## PREFERRED PROJECT REPORT AND RESPONSE TO SUBMISSIONS

**PROJECT APPLICATION NO. 10\_0195**

### **Warnervale Town Centre Civic Precinct – Stage 1**

October 2012

A00.11 PPR - 1

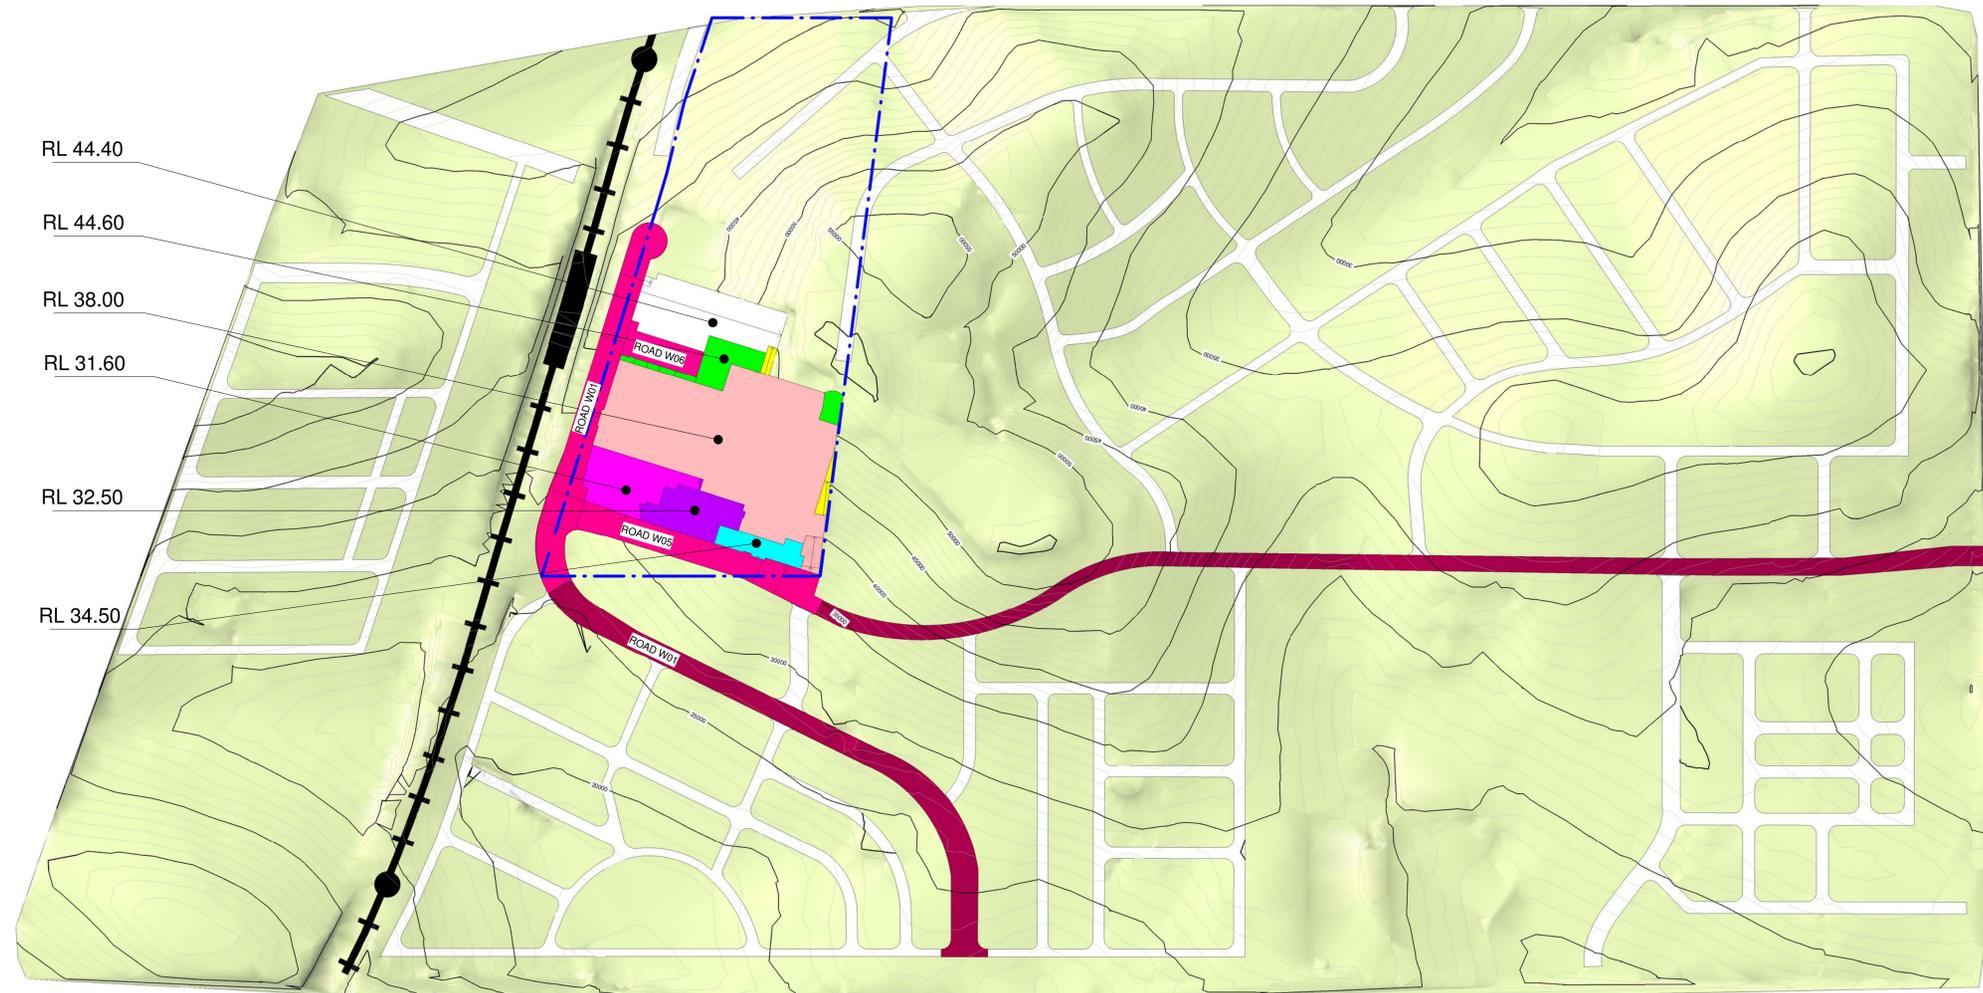
<ul style="list-style-type: none"> <li><i>The landscape drawings show street furniture images but do not note on the plan where these elements will be located in the square. More detail of the design of the square is required, especially locations for nominated street furniture items.</i></li> </ul>	<p>The drawings have been amended to account for this request – refer to <b>Appendices A and J</b>.</p>
<p><b>Public domain works</b></p> <ul style="list-style-type: none"> <li><i>Provide a plan(s) to illustrate the full extent of all proposed road dedications and public domain works to be undertaken as works in kind.</i></li> </ul>	<p>The full extent of road dedications and public domain works are shown in drawing A00.11 PPR-1 at <b>Appendix A</b>.</p>
<ul style="list-style-type: none"> <li><i>The plan(s) must clearly show the extent of the area of Main Street that is proposed to be dedicated to Council and what is proposed to be retained in private ownership.</i></li> </ul>	<p>The full extent of road dedications and public domain works are shown in drawing A00.11 PPR-1 at <b>Appendix A</b>.</p>
